AW-123-11-TC – 34 The Drive - Trees

OBJECTION – AW/123/11/TC – Tree surgery, 34 The Drive,
Craigweil House Conservation Area

Location Plan

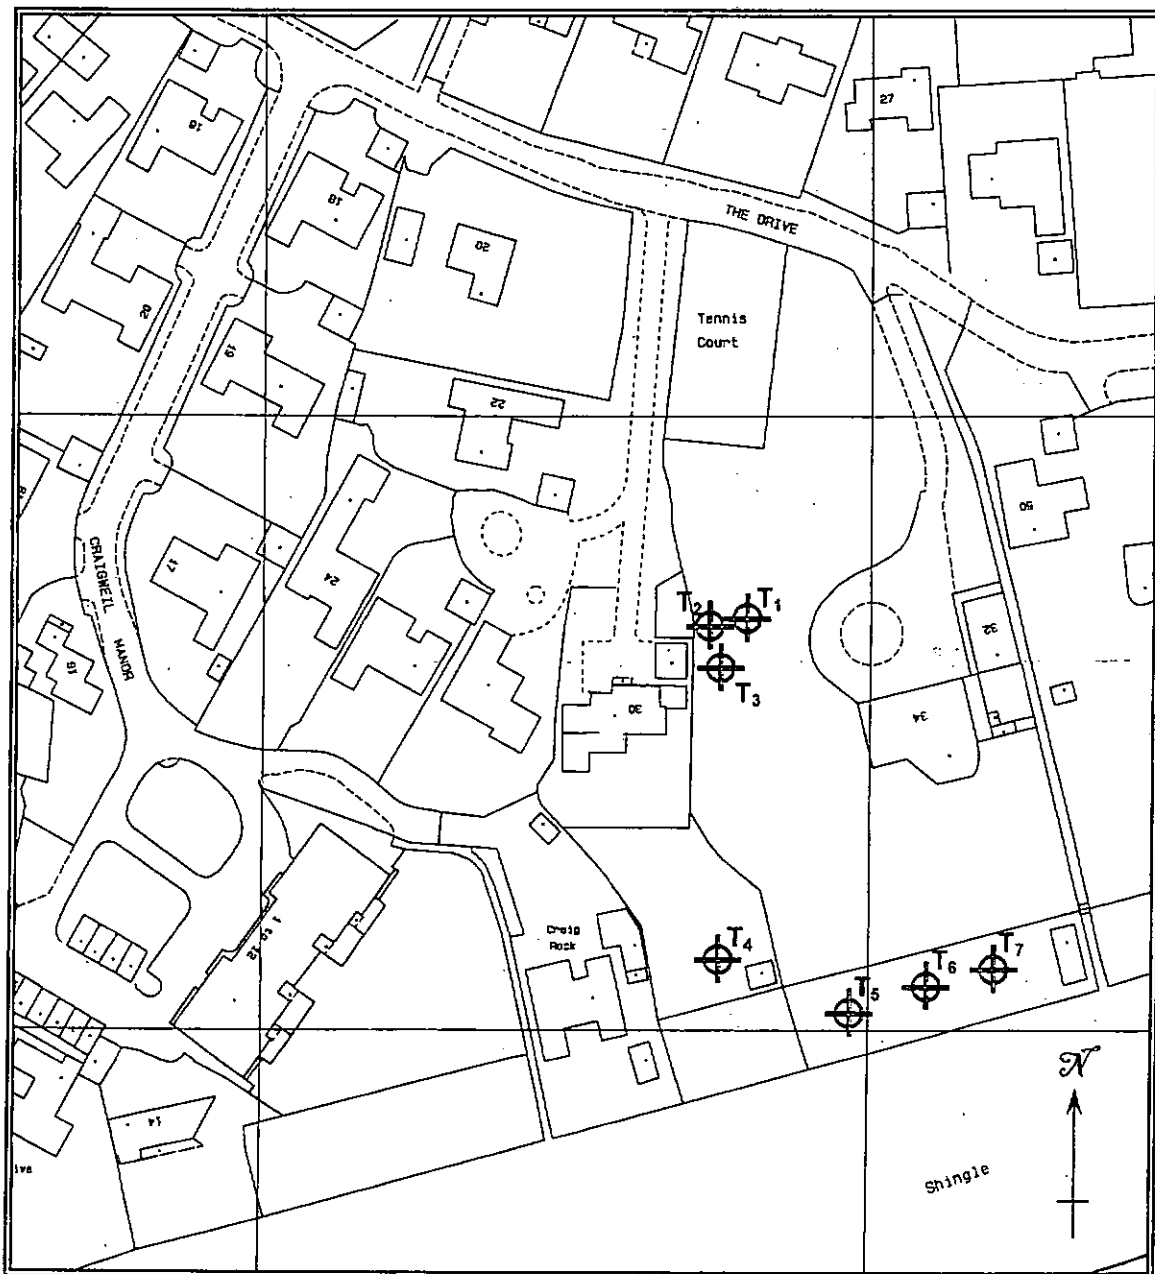
We are doubtful that the extensive lopping and topping described can be justified upon grounds of 'assymetry'(sic!) or that 40% can be justified in most situations, particularly upon the grounds stated of 'reduce excessive shading and improve structure balance of Holm Oaks. The symmetry of trees is of nature's making and, we feel, should be left undisturbed for it is the character of the tree that should not be destroyed except for sound arboricultural reasons.

These trees are of considerable age – well over 50-60 years and should be treated delicately to prevent harming them and in the interests of good husbandry.

Through lack of information we have no alternative but to object to these works but we ask that the Principal Arboriculturalist, please, be asked to inspect and report upon all the trees which are declared as being subject to the protection of TPO BR/2/1958 but may well also be protected by a recent TPO resulting from the recent survey by Colin Bashford and Partners.
